# City of Albuquerque Stormwater Construction Site Inspection Report

ESC File No.	H10E033	Project Name:	2200 Vista Oriente		
NPDES Id. No.	NMR10036M/NMR10060F	Location:	2200 Vista Oriente		
1/12/2024	Owner	Contractor			
Operator	Tuan Huynh				
Contact name & title	Tuan Huynh				
e-mail	<a href="mailto:tuanvhn@yahoo.com">tuanvhn@yahoo.com</a>				
Contact Phone #	505-269-1418				
COA Inspector	Chancellor English	Start/End Time:	2pm		
Construction Phase:	none, weeds and partial land disturbance				
Type of Inspection:	Regular	Storm Event	Post Storm Event >0.25"	311/Complaint	
Weather at time of inspection?		Clear	Temperature: ~	40	
Estimated date of last storm 0.25" or greater		12/22/2023

Narrative

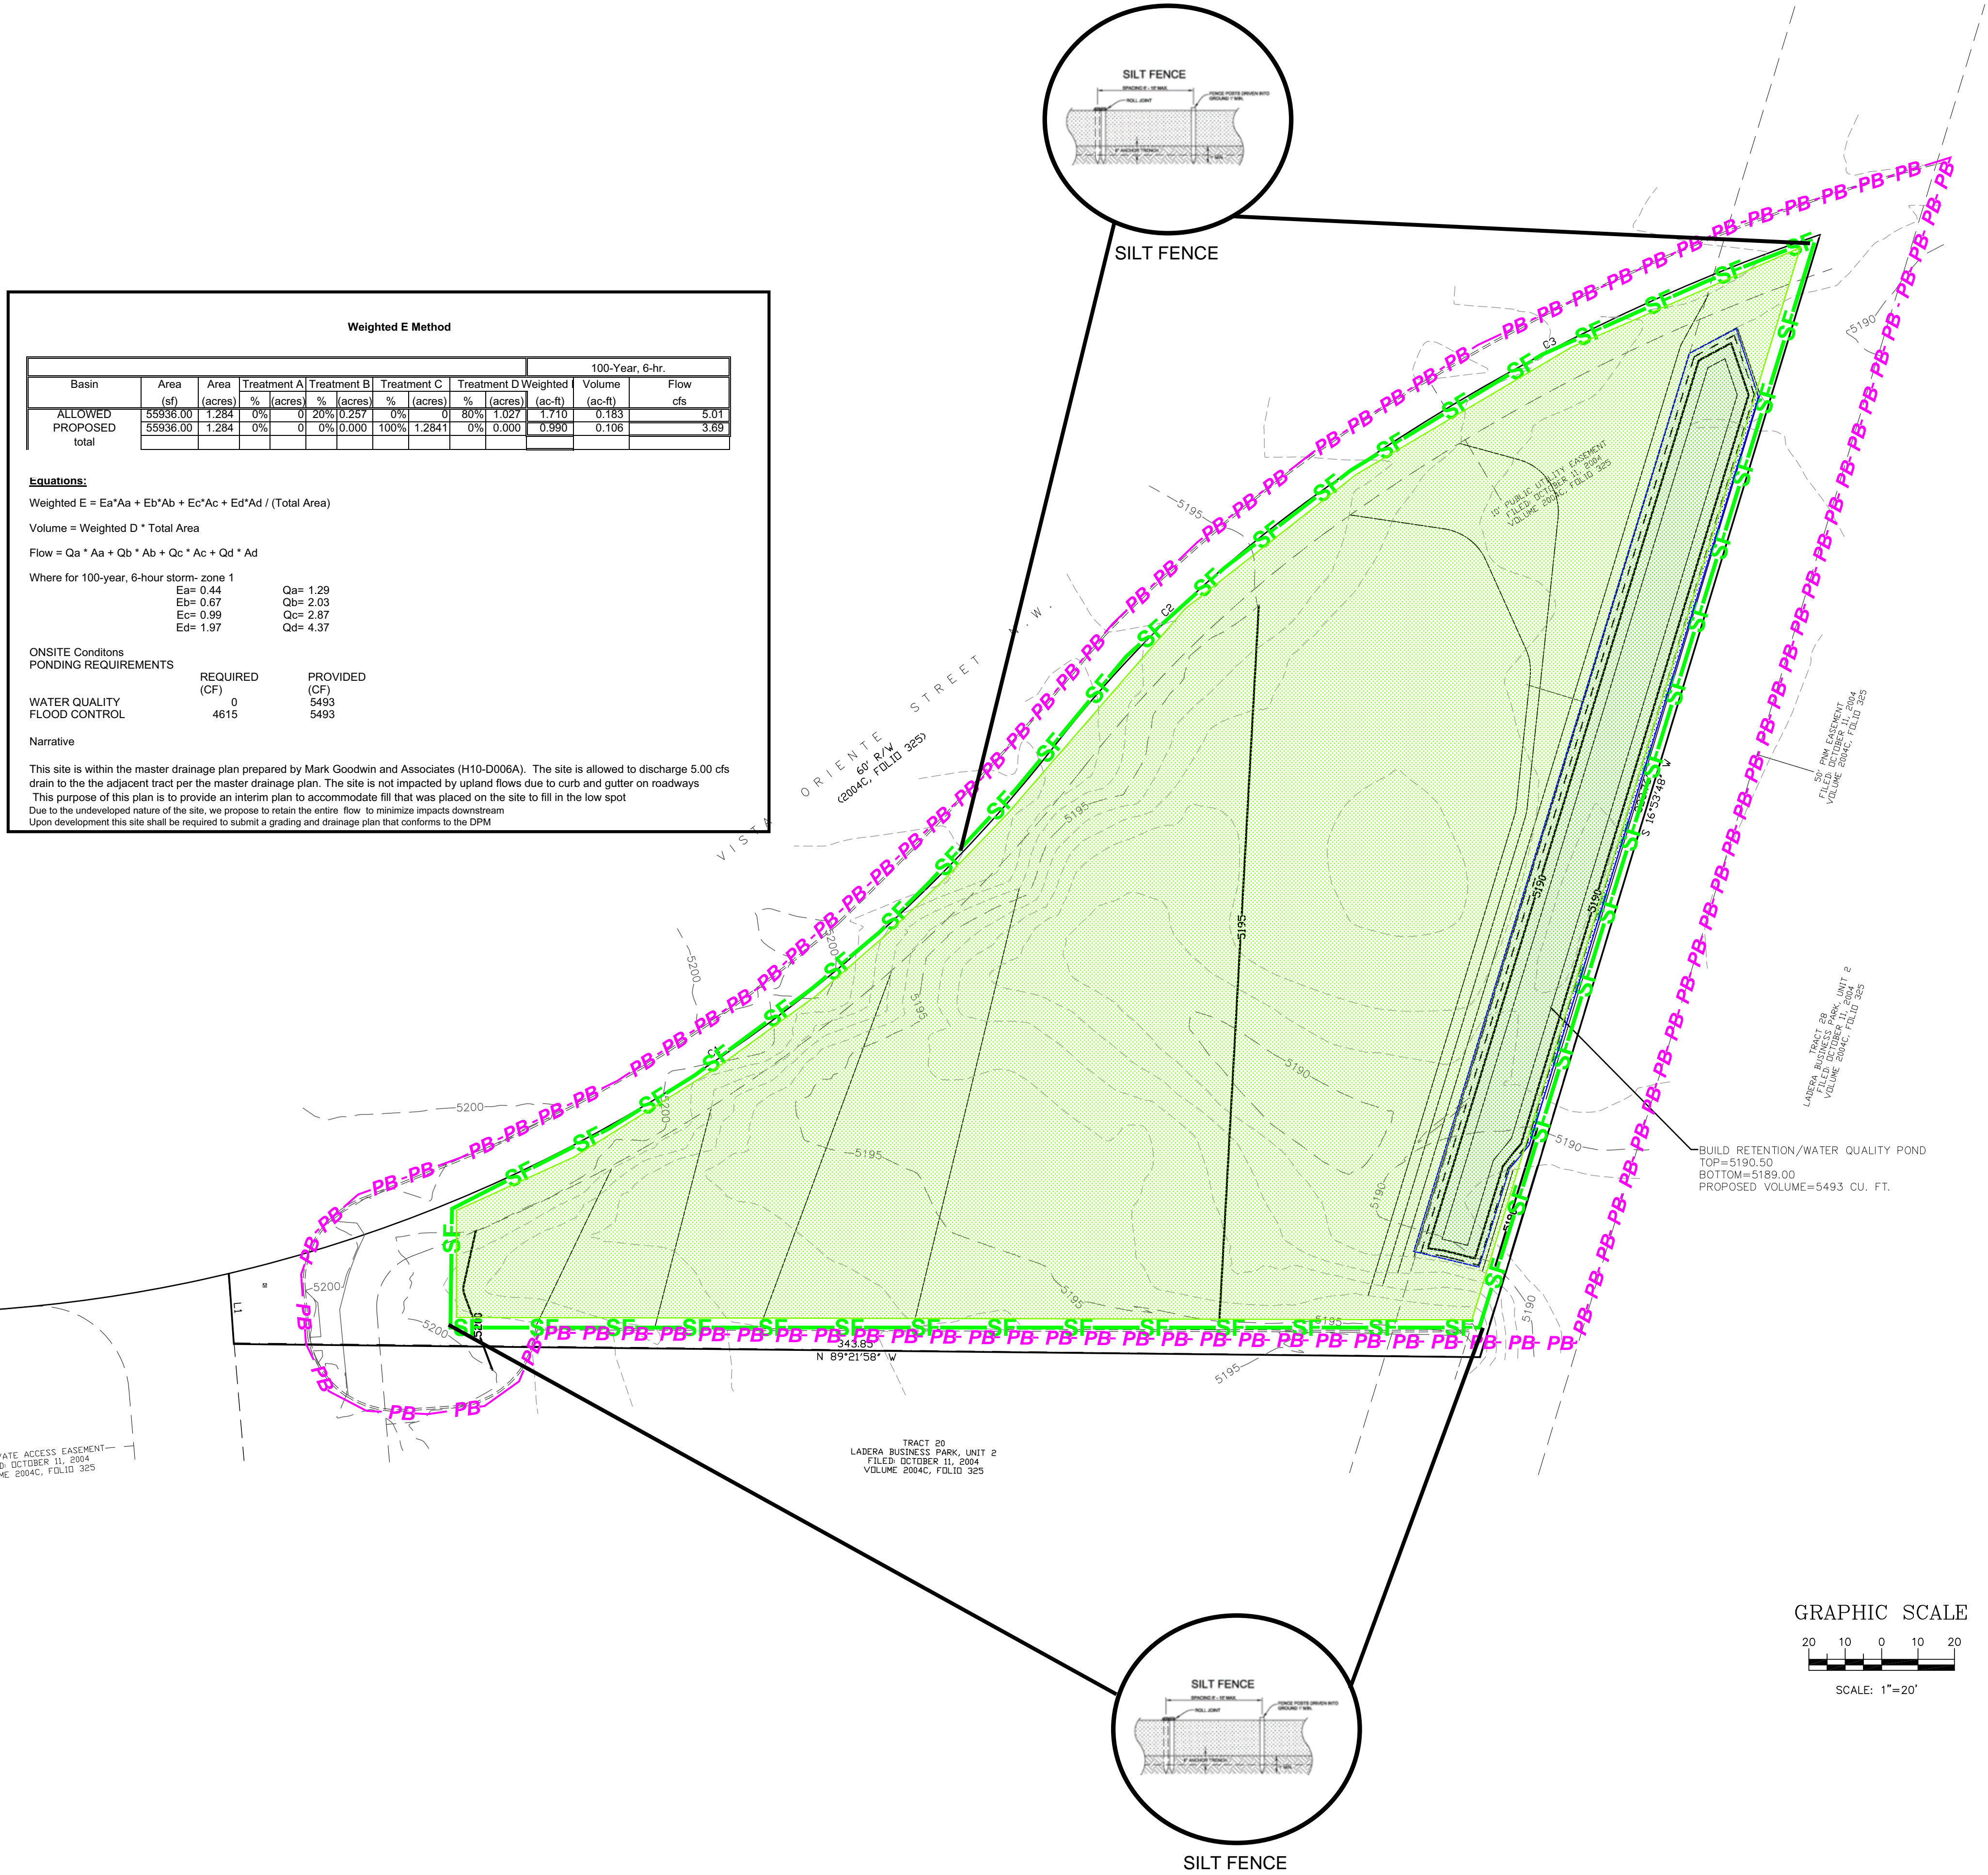
Item Number	Deficiency/ Corrective Action				
1	The site is still lacking compliant stabilization per CGP Part 2.2.14. The weeds are not sufficient vegetative cover and have become overgrown in violation of City Ordinance 9-8-4. The disturbed area needs stabilization. Required mitigation: Maintenance of weeds and stabilize any recently disturbed soil at the site if no construction activity for 14 or more calendar days as per CGP Part 2.2.14.

Notes:	Recent land disturbance on east side of site has been graded, but not stabilized
Prior violations for Posting, SWPPP, BMPs, and stabilization	
Weeds are becoming overgrown again and exceeding the 4" width and 4" height allowed by City Ordinance 9-8-4.
